Submission of Fabian and Donna McMorro

Development: Lissinagroagh Wind Farm

Applicant: FuturEnergy Ireland

Case Reference: PAX12.324290

Title:
 DRAINAGE LAYOUT PLAN
 Sheet 1 of 6

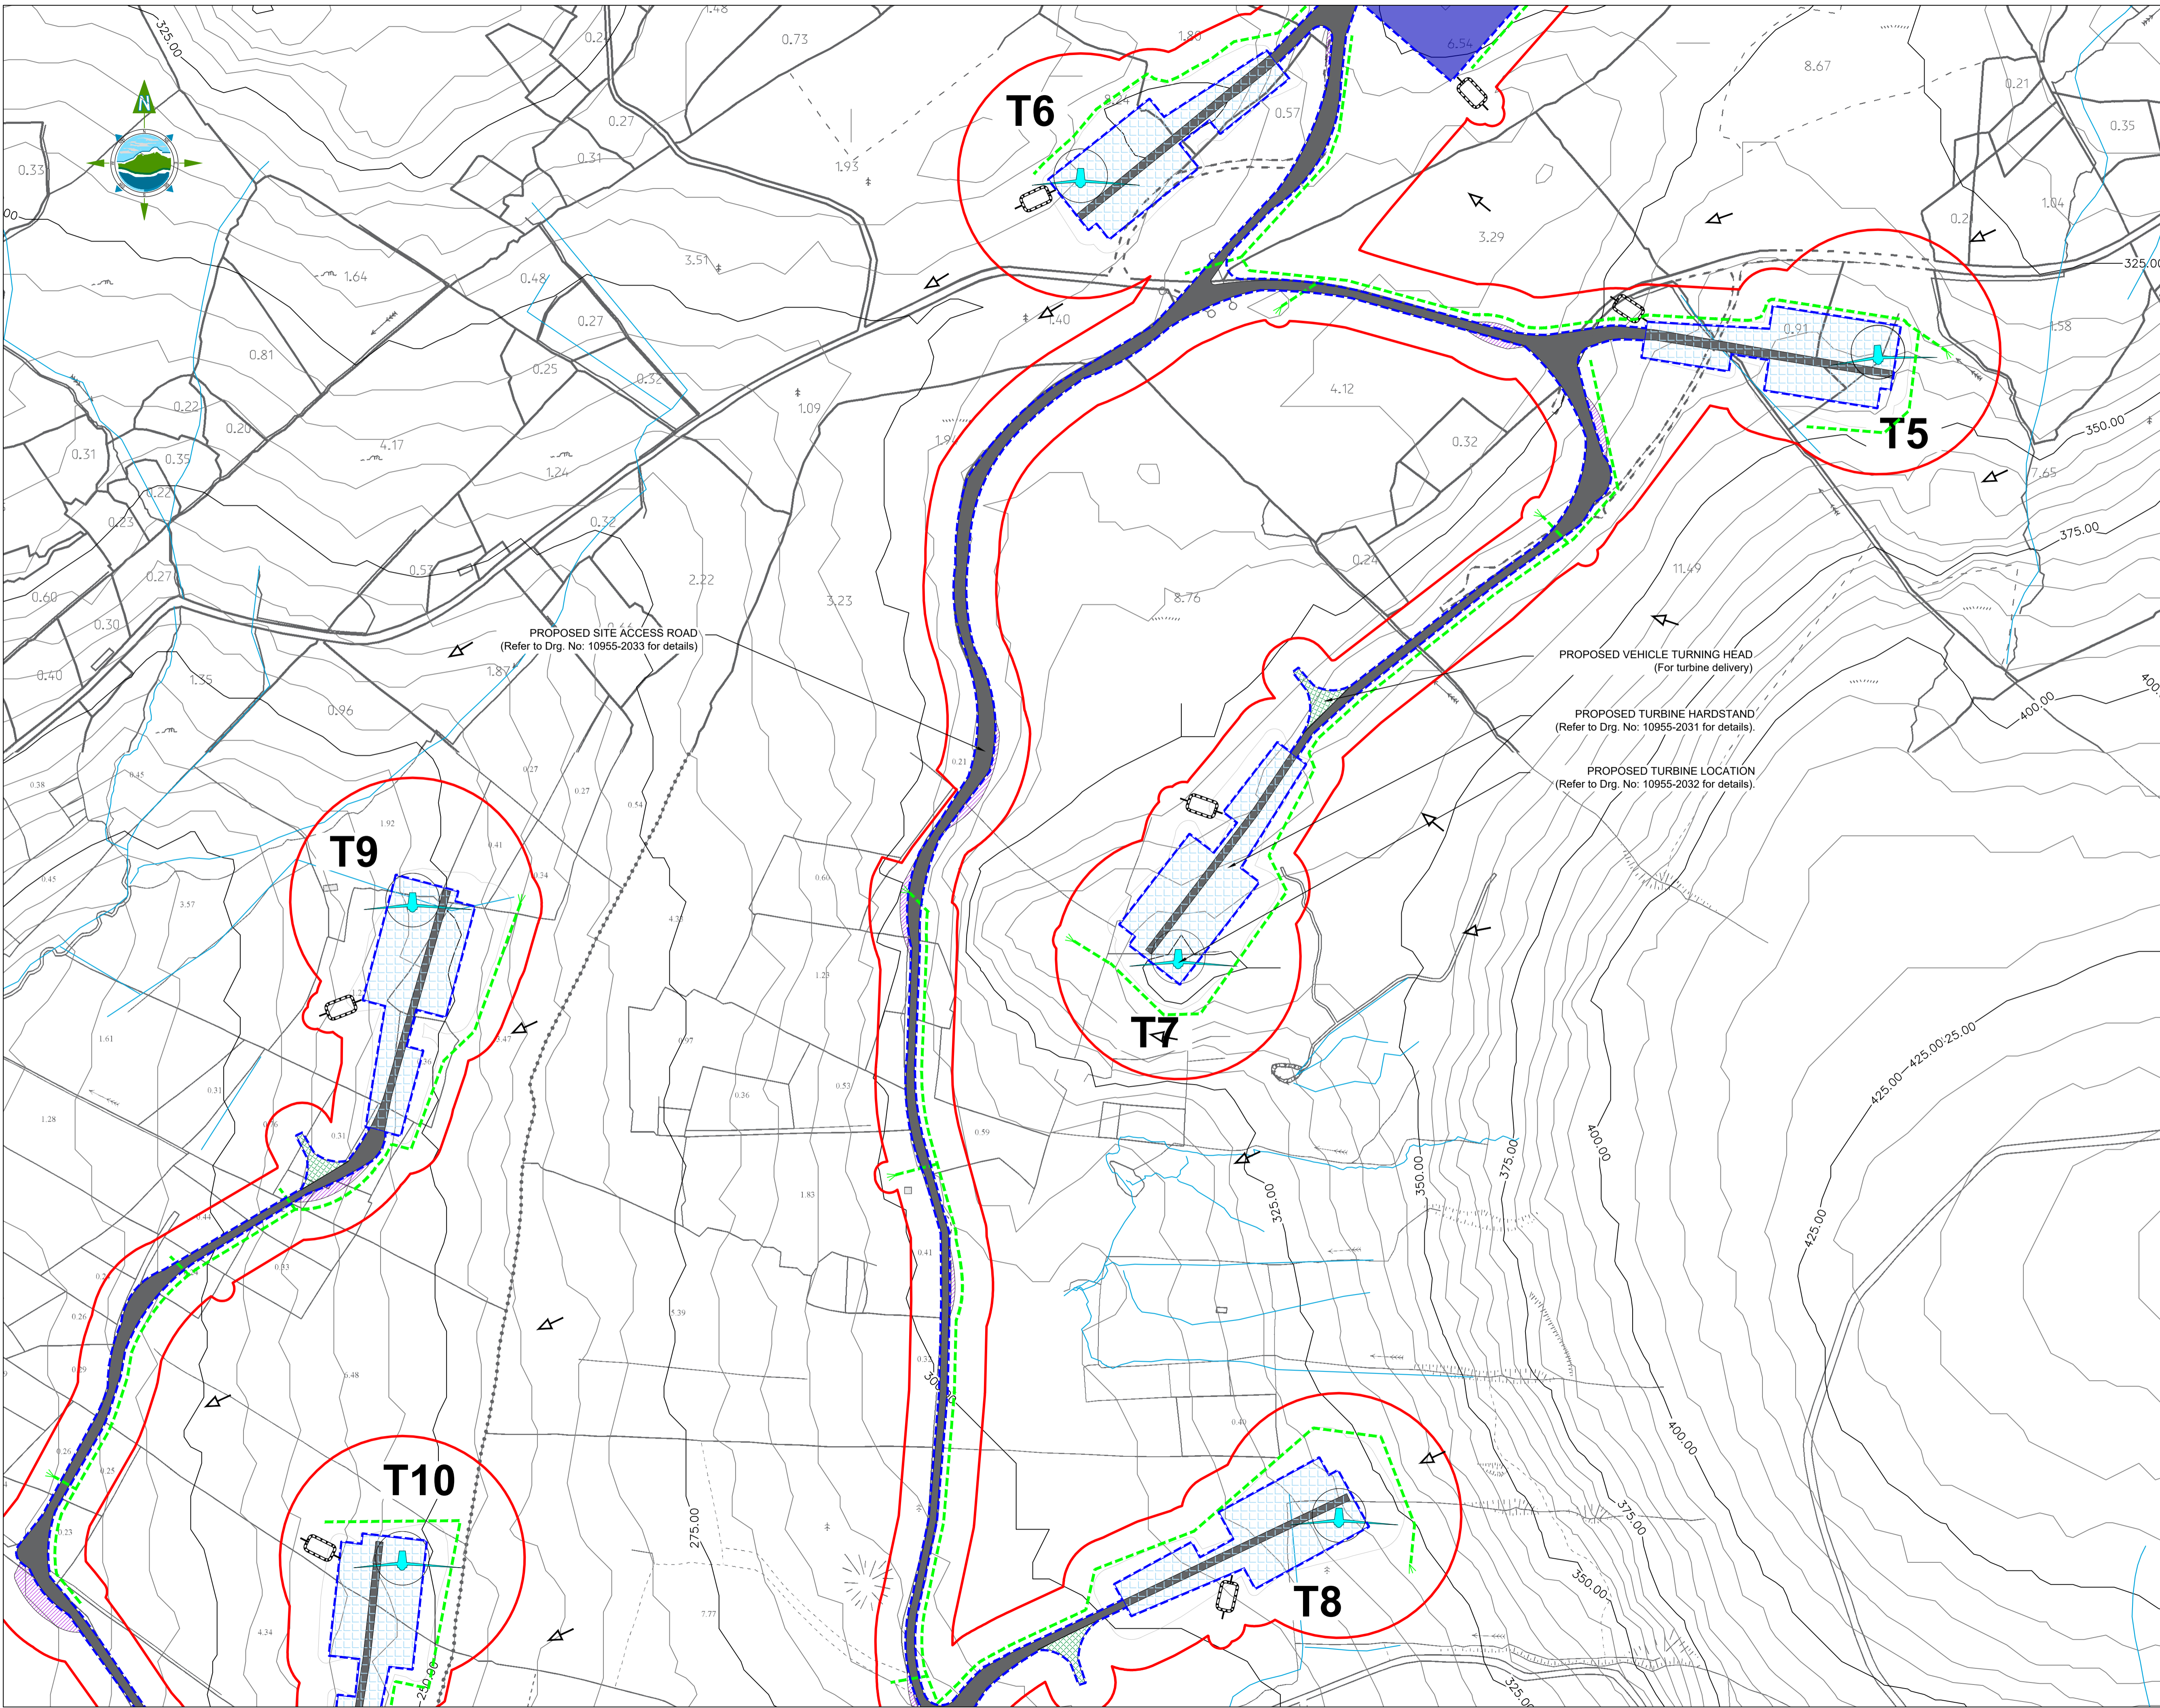
Having examined **Drainage Layout Plan 1 of 6 (Drawing No. 10955-2051)**, we note that a proposed interceptor drain is located between AH01 and Turbine T3. Based on approximate measurements taken from this drawing, the interceptor drain appears to pass within approximately **50–60 metres** of the archaeological monument. As the drawing contains no dimensioned offsets or separation distances, this measurement cannot be independently verified and could only be confirmed by the applicant.

In our view, the application should have clearly identified and dimensioned the relationship between AH01 and all elements of the proposed development, including turbine foundations, hardstands, crane pads, cable trenches, interceptor drains and any other associated excavation works. Without this information, it is not possible for the Board or members of the public to properly assess the potential impacts of the proposed development on this protected archaeological site.

Figure 1.1 below reproduces **Drainage Layout Plan 1 of 6 (Drawing No. 10955-2051)**. The proposed interceptor drain has been highlighted in **green**, while the location of archaeological monument **AH01 (LE008-006001 & LE008-006002)** has been highlighted in **yellow**. This figure illustrates the proximity of the proposed drainage works to the archaeological complex and highlights the absence of dimensioned separation distances within the applicant's submitted drawings.
